RWE Renewables UK Solar and Storage Limited ("RWE")

Proposed Peartree Hill Solar Farm Order (the "Proposed Development" and the proposed "Order")

Written Representation (Objection) on behalf of Albanwise Limited (Interested Party Reference PHSF-AFP001), Albanwise Synergy Limited, Albanwise Farming Limited, and Field House Renewables Limited¹, collectively ("Albanwise") (Interested Party Reference [REDACTED]) in relation to RWE's change request application submitted to the Planning Inspectorate on 10 September 2025 ("Change Request 9 Application" [REP2-149] setting out "Proposed Provisions") and accepted by the Examining Authority, as confirmed by letter dated 19 September 2025

**SWEPT PATH ANALYSIS MASTERPLAN
- FLAT BED 19.89m REAR STEER**

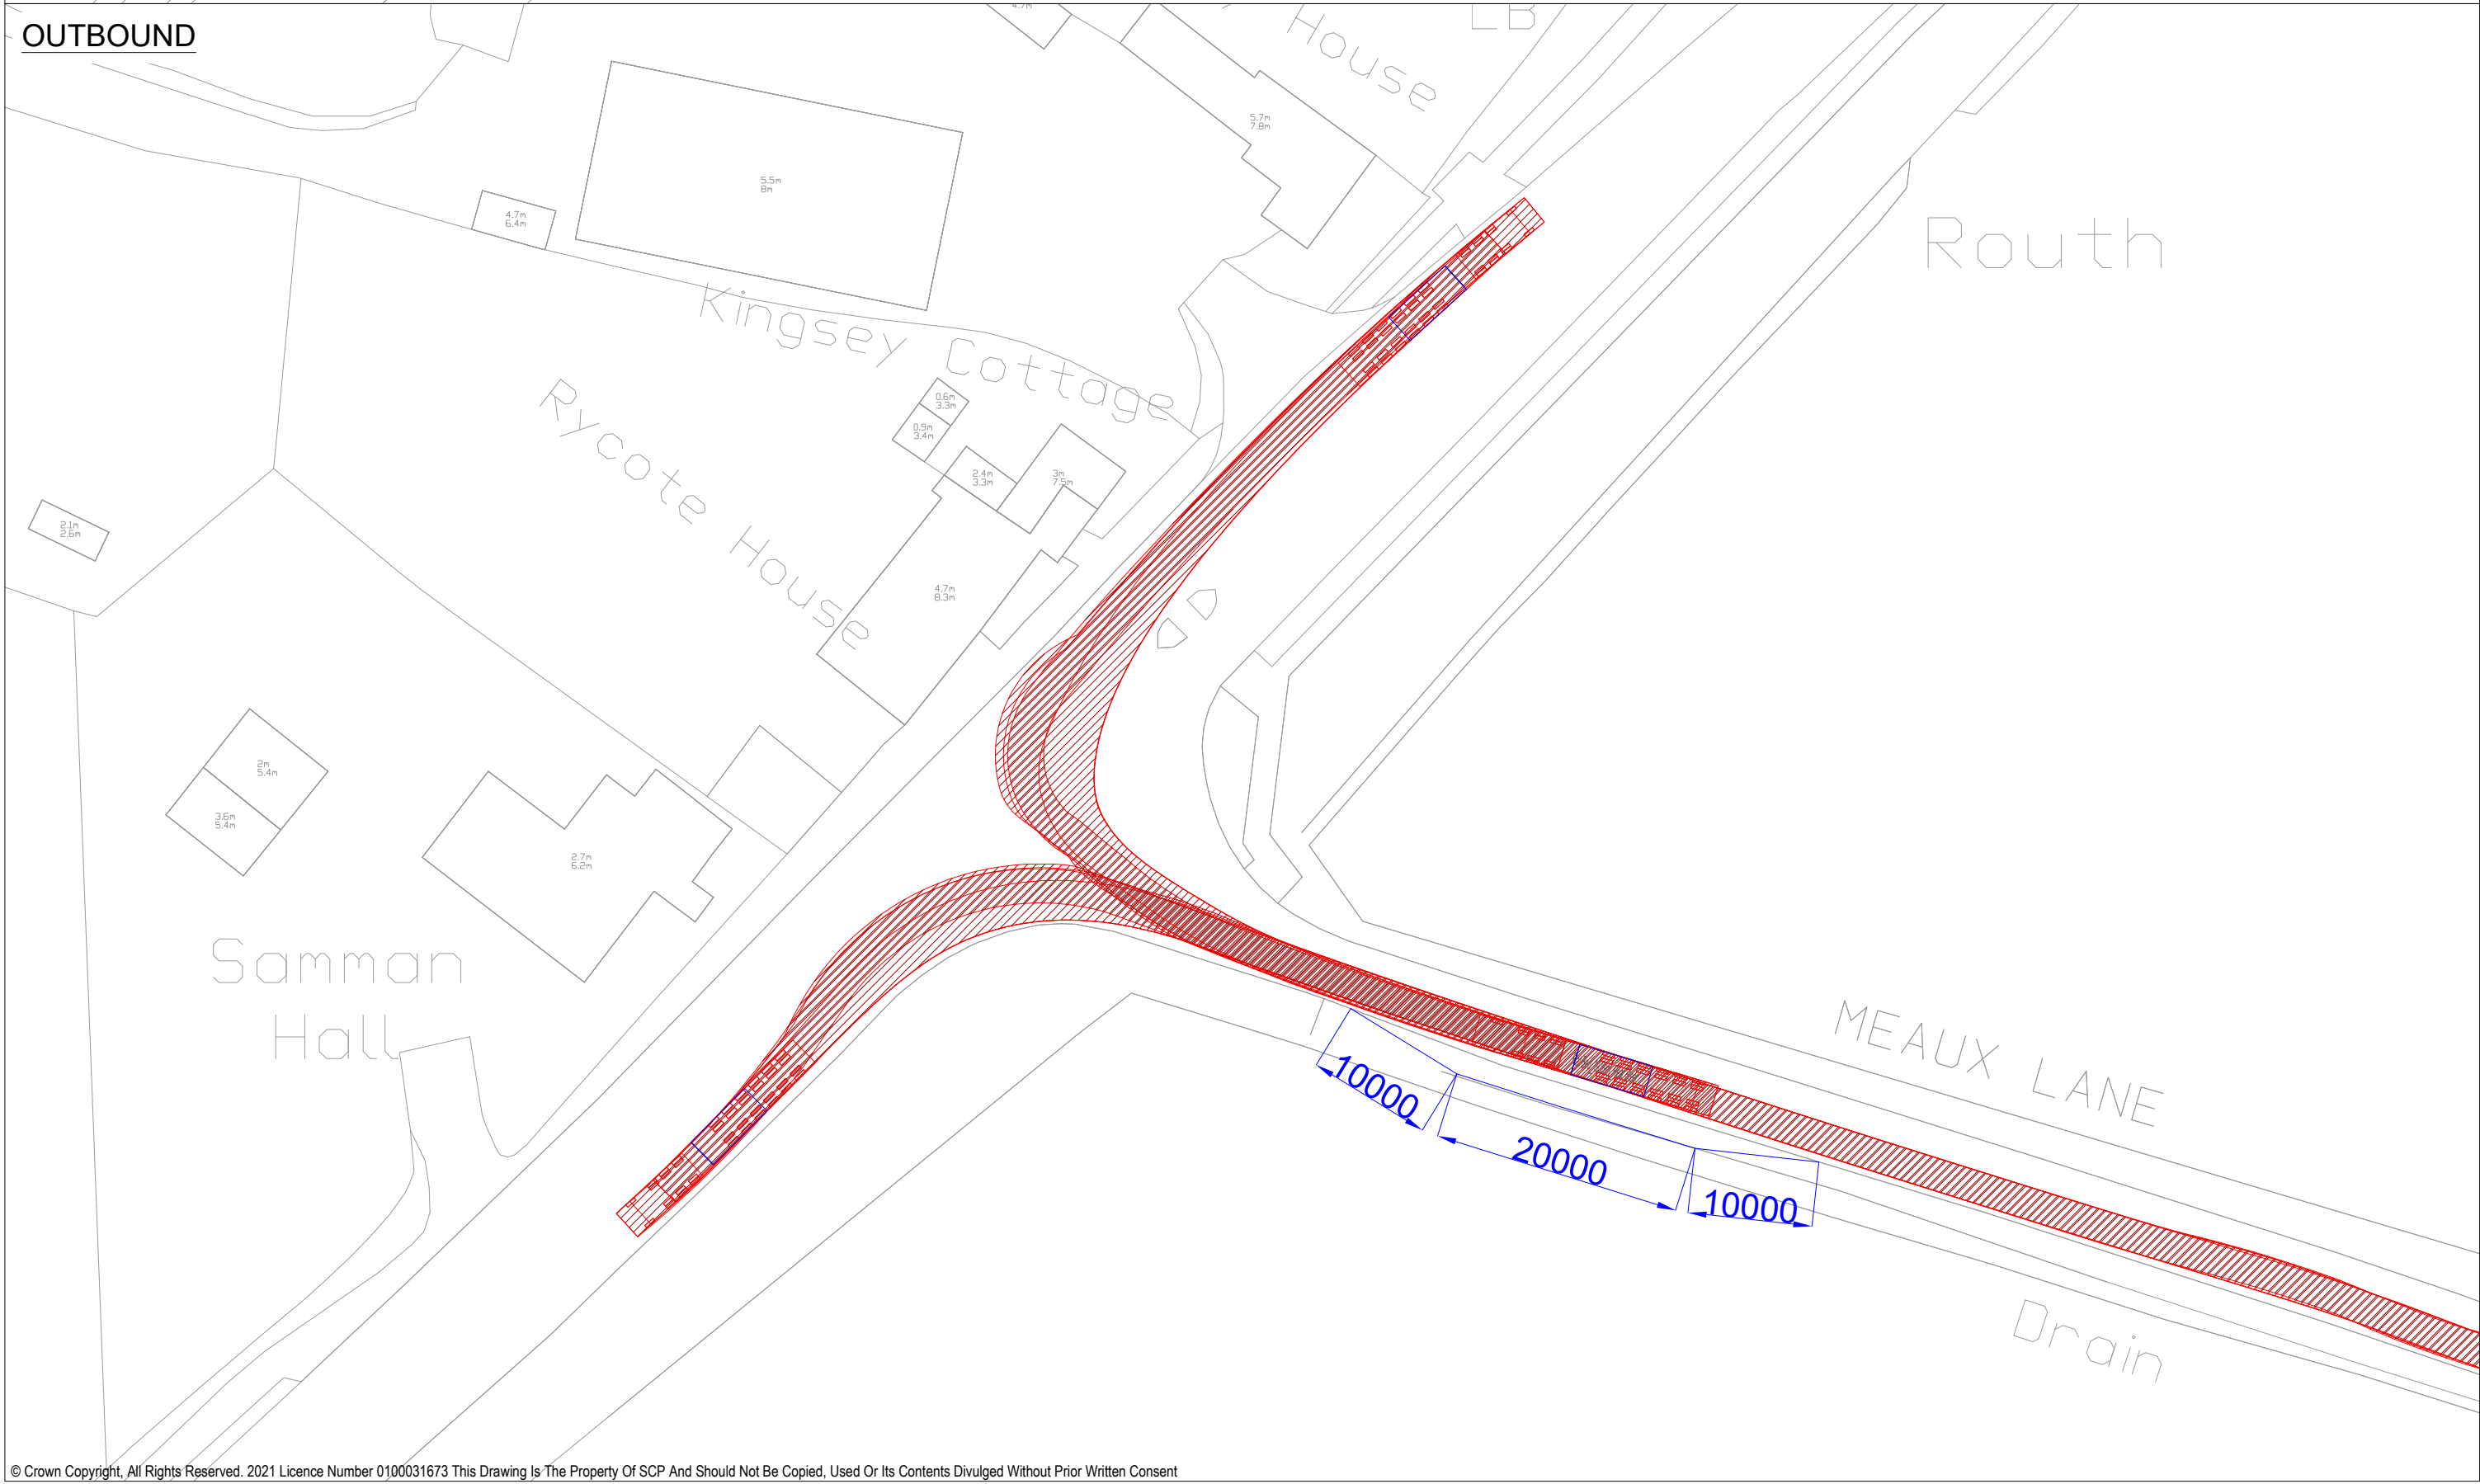
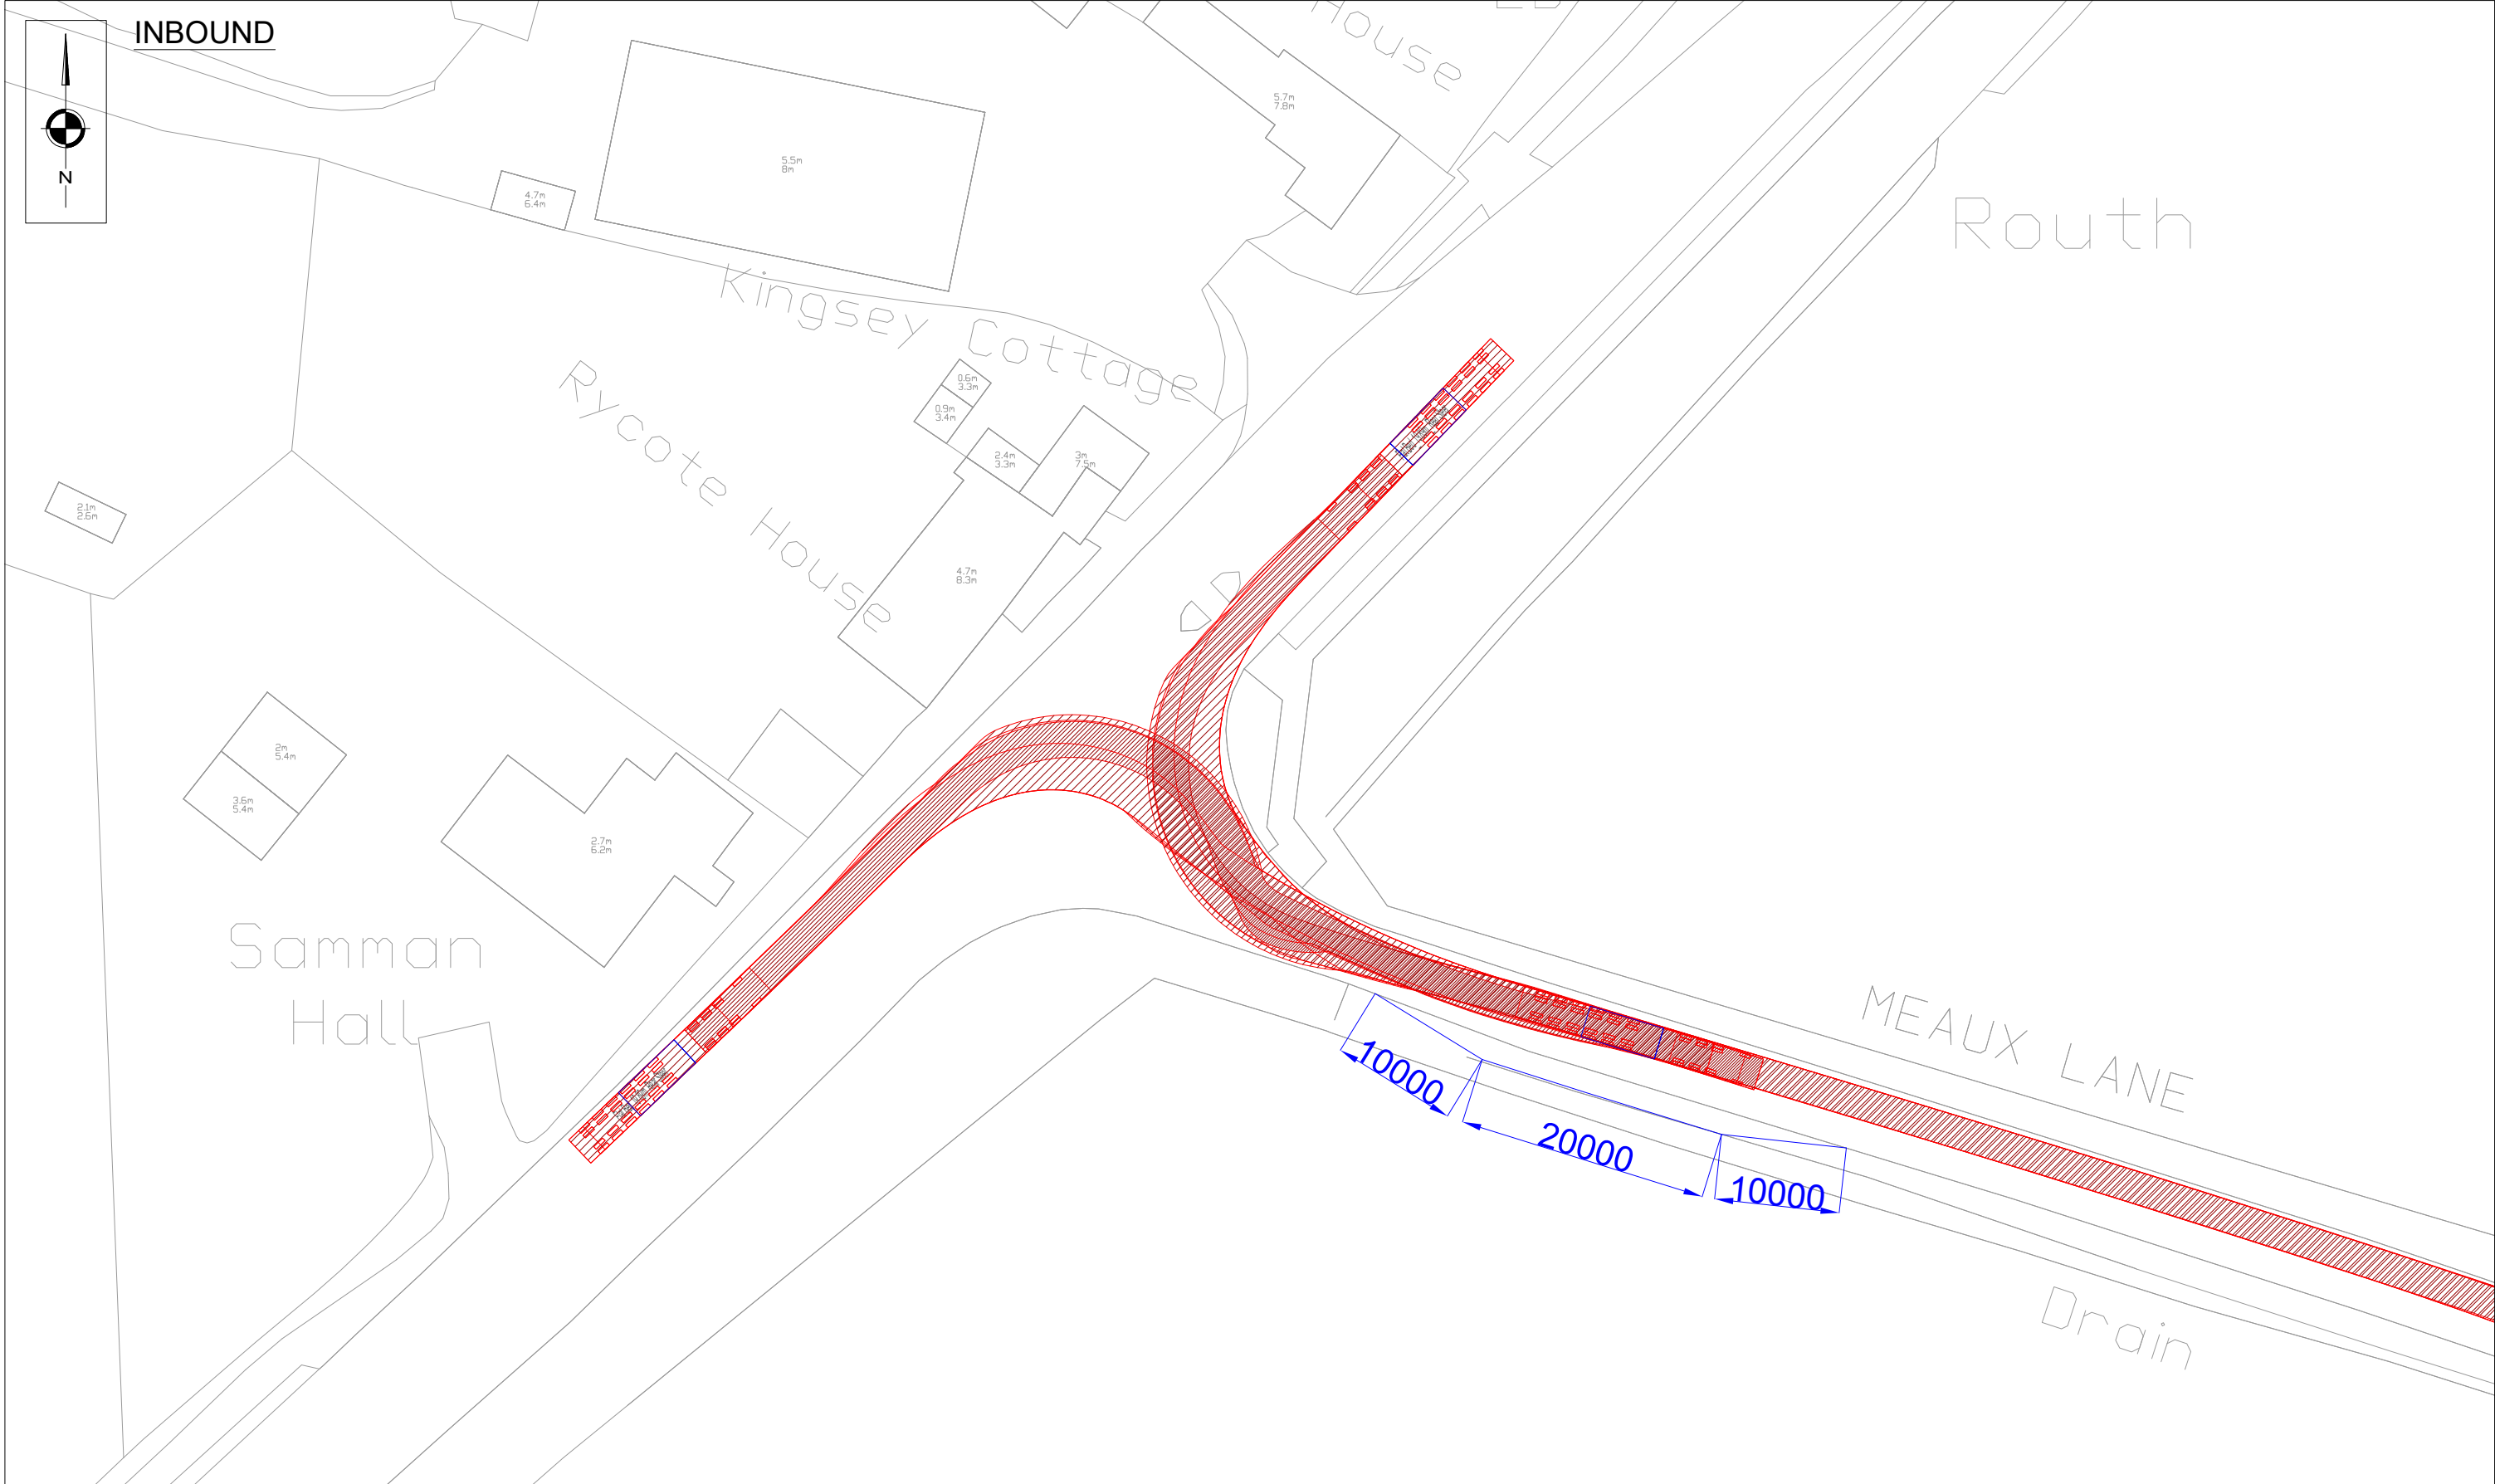
Tracking drawings provided by RWE showing vehicle movements at the junction indicate two locations where two-way traffic operation is not possible and incoming and outgoing vehicles would clash (or potentially crash) and the junction would therefore require special management measures to be put in place.

The potential risks associated with traffic blocking back to the A1035, include the following:

- A banksman has no legal powers to stop or hold traffic on the A1035 public road (note only the Police have the powers to do this);
- There is no indication where a banksman would be positioned. Given the inability for HGV traffic to pass unimpeded between the public road and the Existing Access Track, at least two banksmen would be required and given the complex constrained turns, they would need to be

- The positioning of banksman on the verge of 50mph speed road is considered very dangerous and does not appear to be compatible with Health & Safety regulations. For the banksman to be effective in identifying construction traffic, they would need to be positioned in close proximity to the existing hedge line in order to see traffic turning into the access junction. This puts them at the edge of the verge of a 50mph speed limit road;
- No detail on banksman shift patterns and communications protocols have been provided by SCP on RWE's behalf; and
- No detail had been provided as to how an RWE employed banksman would co-ordinate the movement of construction traffic travelling to/from the Proposed Peartree Development via the access junction alongside Field House Solar Farm construction traffic, agricultural traffic and residential traffic.

This last point is especially crucial and lies at the heart of Albanwise's safety concerns. The Transport Report shows that traffic management at this junction is essential because two HGVs cannot freely pass one another. The Principal Contractor on one project can easily ensure a safe system of work which schedules and manages deliveries for one project (and Albanwise have specifically addressed this in the Field House Construction Traffic Management Plan (CTMP)). The complications and safety concerns increase when there are two projects, working to different systems, overlapping one another in the same physical space and no detail as to how this would be managed has been provided by RWE, other than a reference to Requirement 16.
